DRB Application No.: 04DRB-01004 [REDACTED] FP Project # 1002731
Project Name: ALBRIGHT-MOORE ADDITION
Agent: Jeff Mortensen & Associates Phone No.: 345-4250

PROJECT # 1002731 APPLICATION # 04-01004

RE: Albright-Moore Addition/final plat

PLAT OF
**LOTS 24-A, 25-A, 26-A AND 27-A,
 BLOCK 12, ALBRIGHT-MOORE ADDITION**

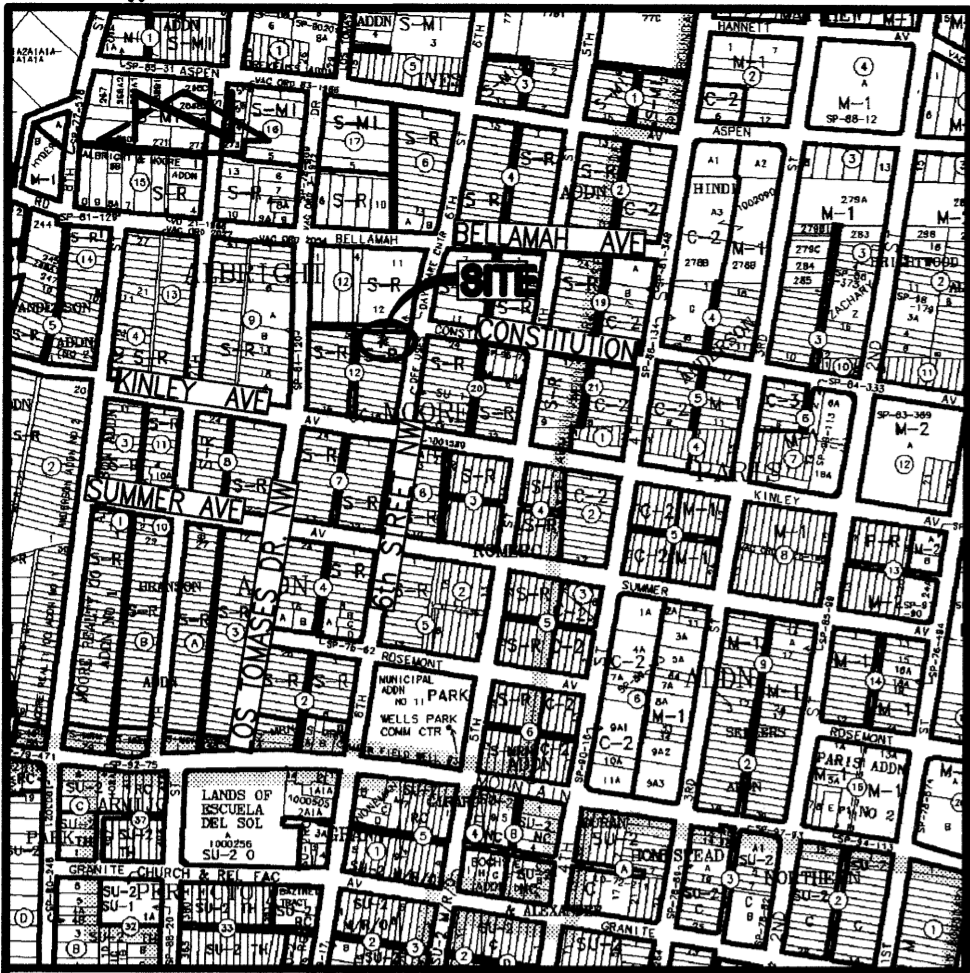
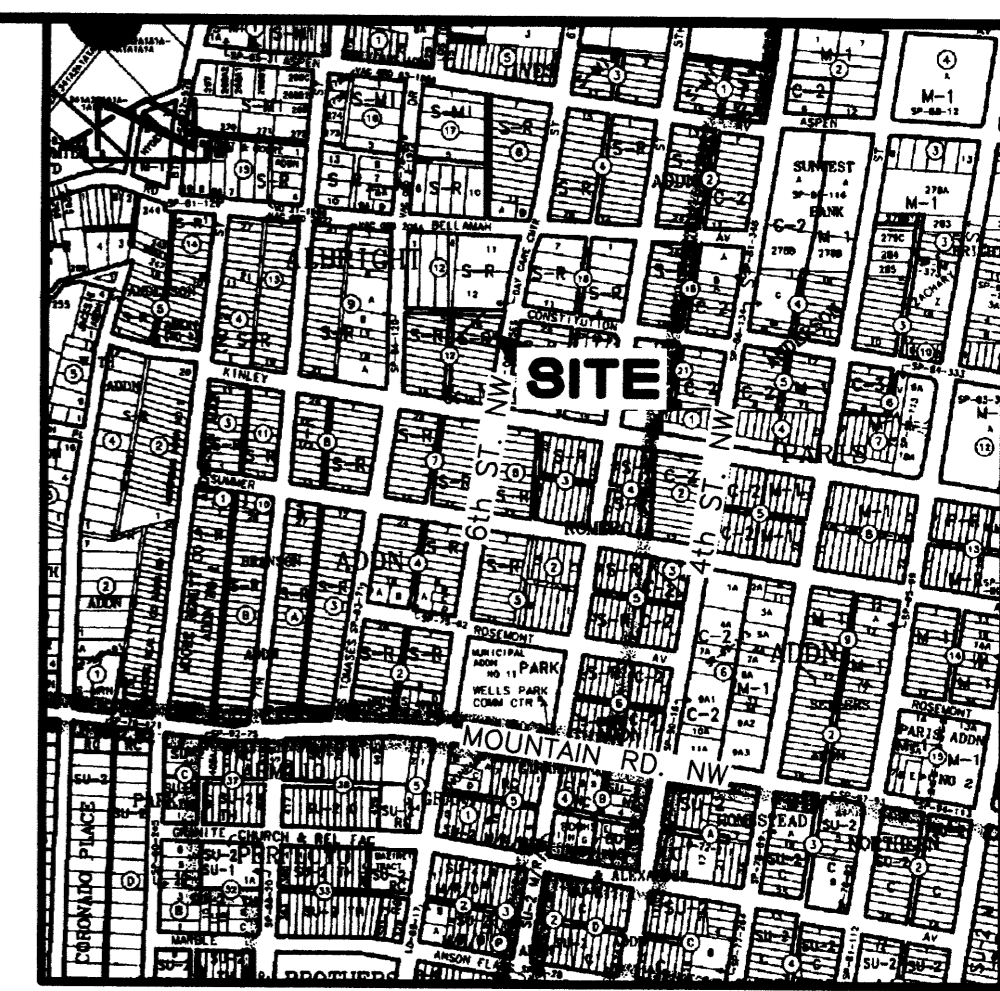
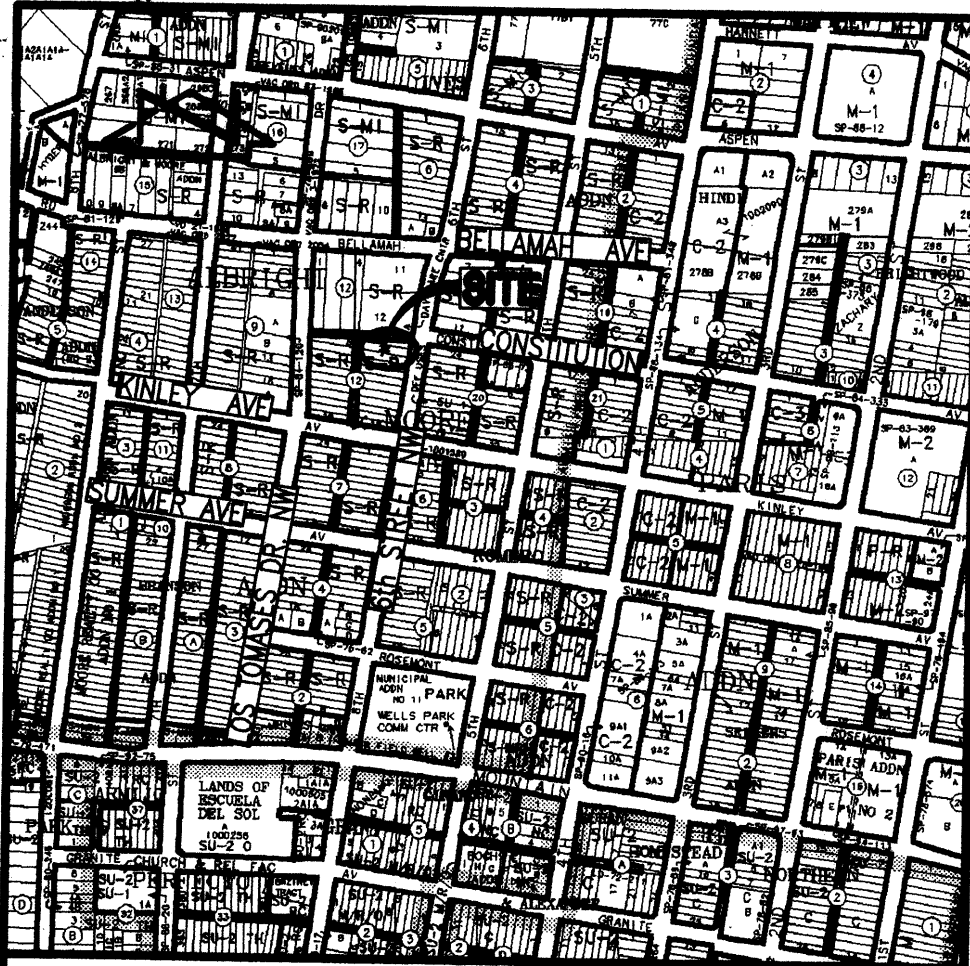
No objection to the final plat approval provided the fee simple title language is on the plat.
